PLANNING APPLICATION CONSULTATION RESPONSE

Application Number:	3/2024/0389
Proposal:	Approval of details reserved by conditions 8 (tree and hedgerow protection), 9 (construction traffic management plan), 14 (surface water drainage strategy), 15 (construction SW management plan), 16 (SW drainage operation and maintenance manual), 17 (SW verification report) and 20 (Phase 2 land contamination report) of planning permission 3/2021/1262.
Location:	Land at the North of the Chapel Hill site Longridge

Lead Local Flood Authority Position

EXCEEDANCE FLOW

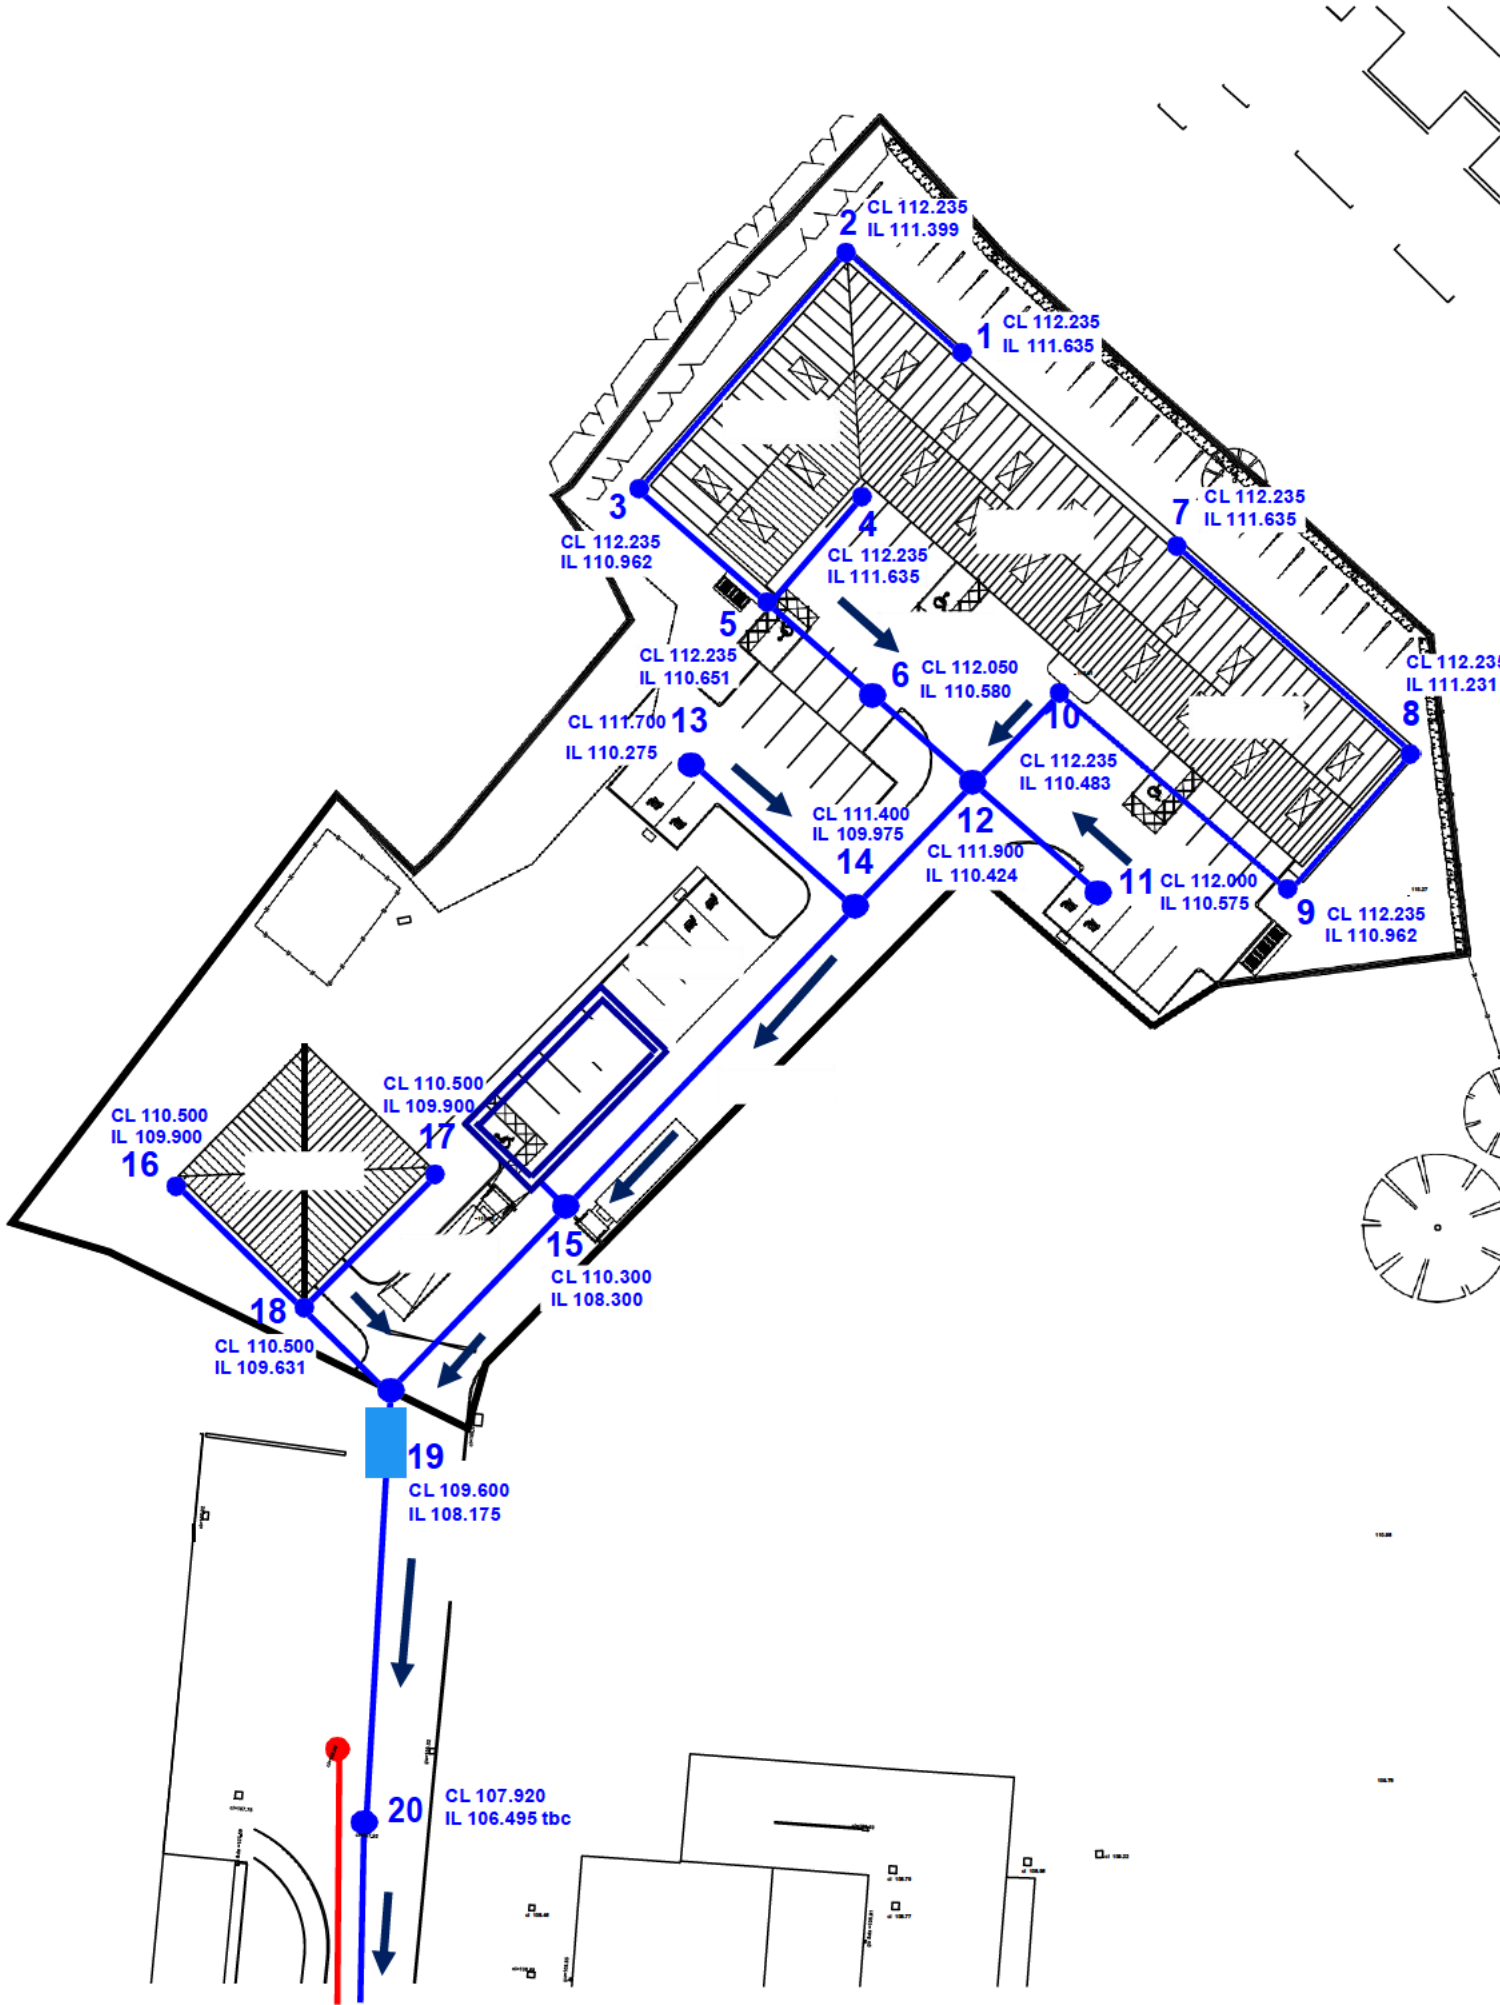
- The applicant has failed to provide a drainage plan showing flood water exceedance route in accordance with Defra Technical Standards for Sustainable Drainage Systems.
- The applicant has failed to provide Finished Floor Levels (FFL) in AOD with adjacent ground levels for all sides of each building and connecting cover levels to confirm minimum 150 mm+ difference for FFL.

CONSTRUCTION DRAINAGE

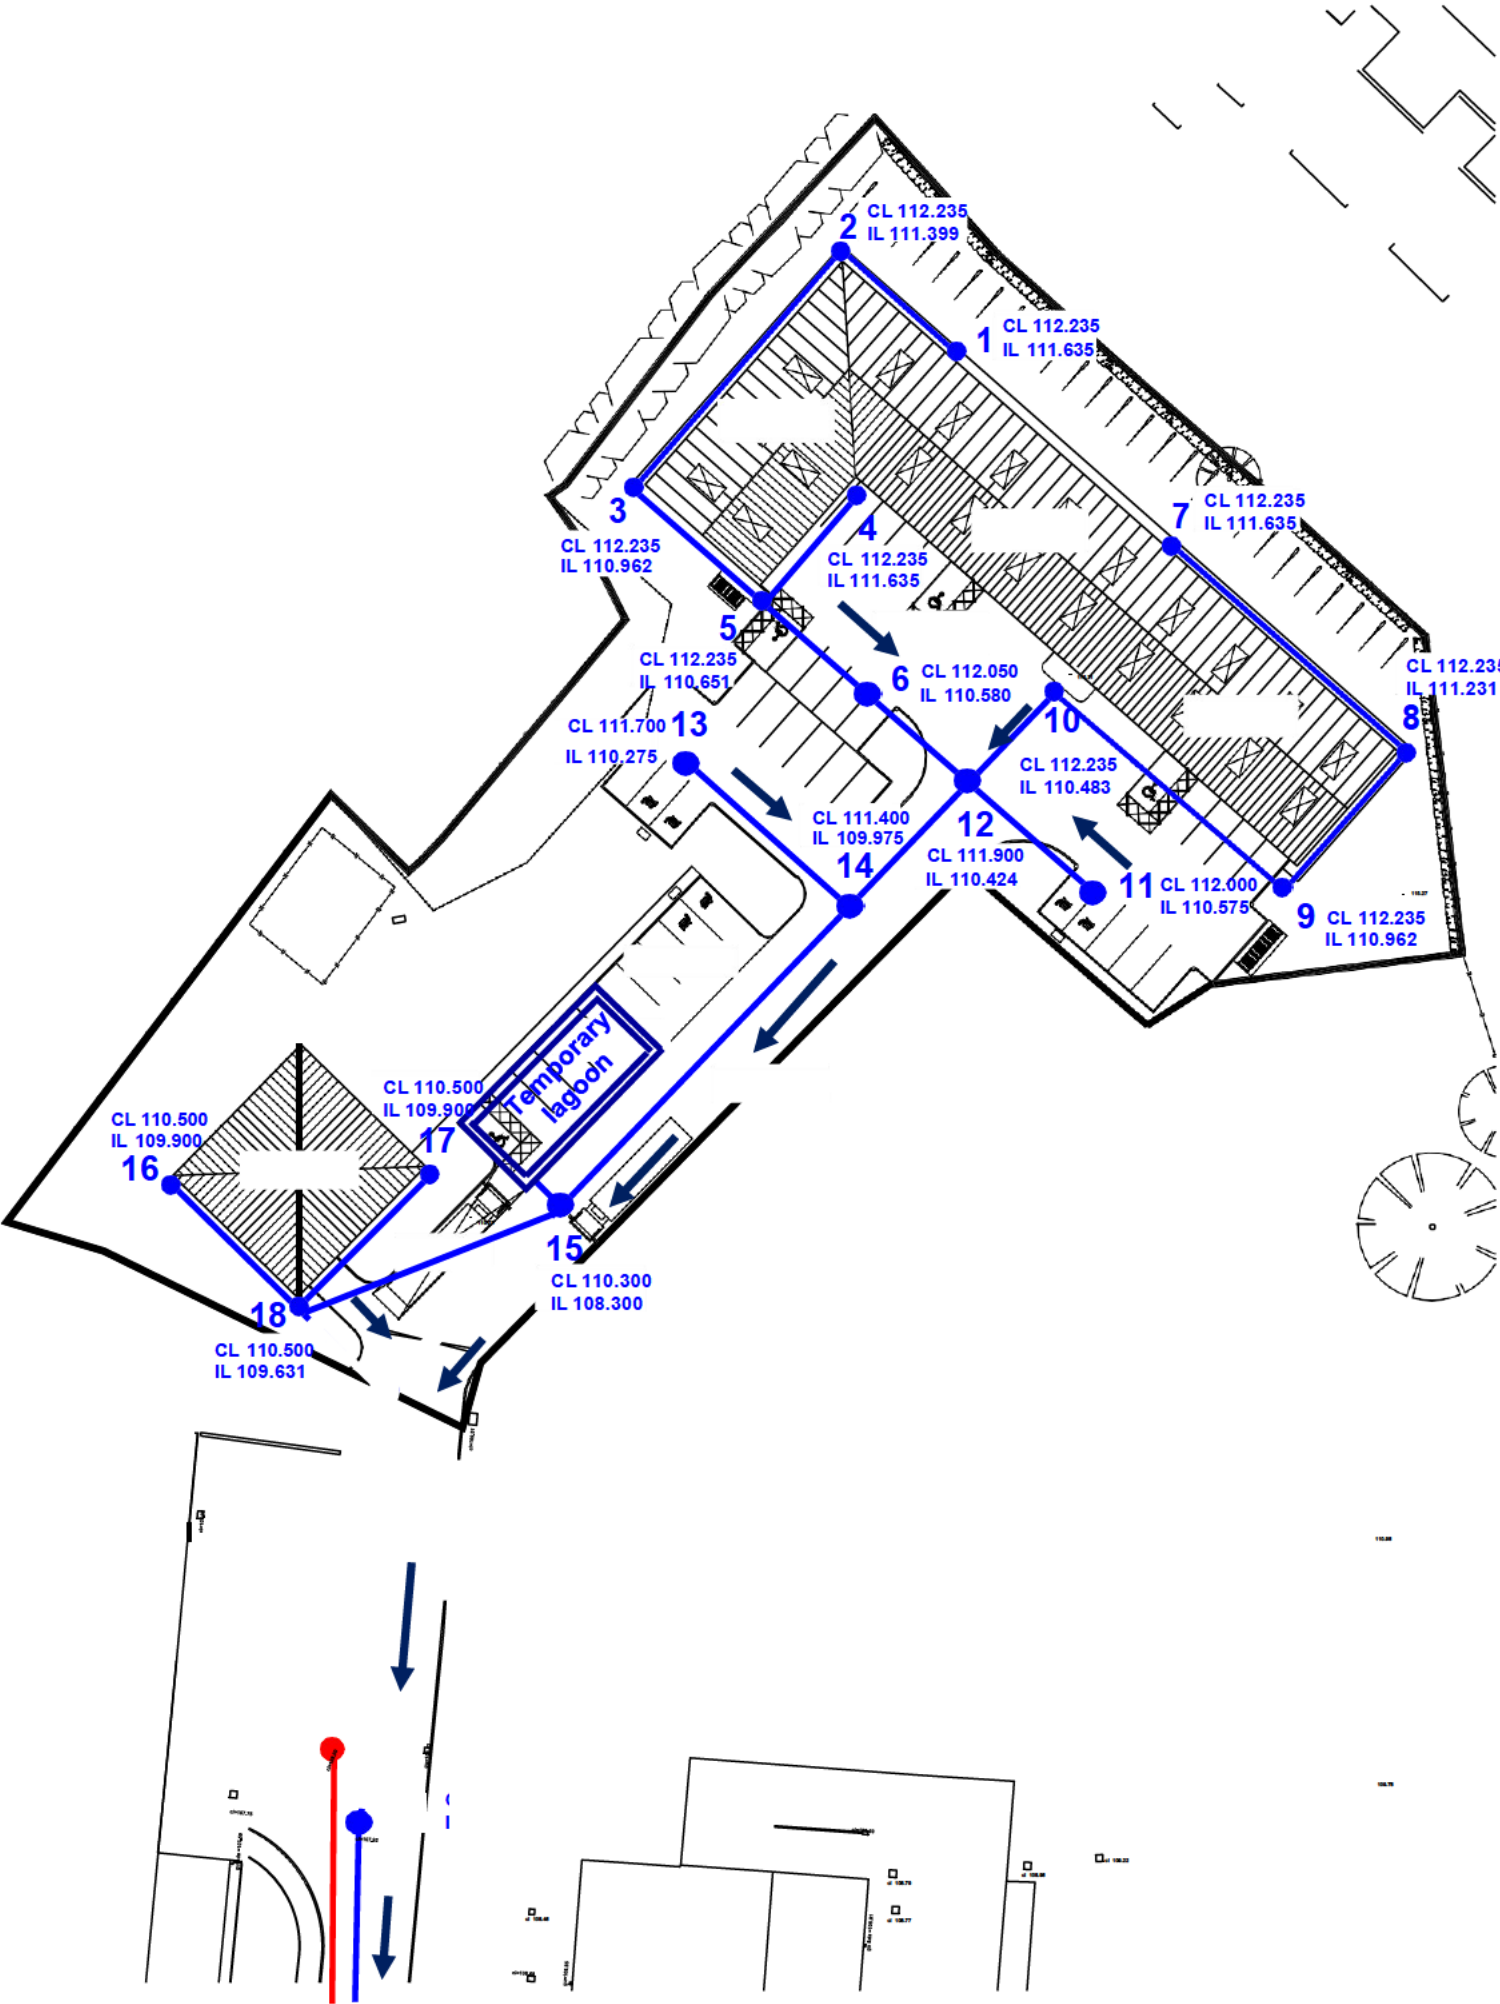
- The applicant has failed to provide a site layout that demonstrates the principles outlined in the construction surface water management plan.
- The applicant has failed to provide evidence of the proposed restricted discharge rate of surface water from the temporary lagoon to the existing private surface water drainage system.
- The applicant has failed to provide full evidence to demonstrate that siltation and pollutants will be prevented from affecting surface water, and watercourses, apart from stating that silt will be allowed to settle in the temporary lagoon, this is important given the sites proximity to an existing pond.
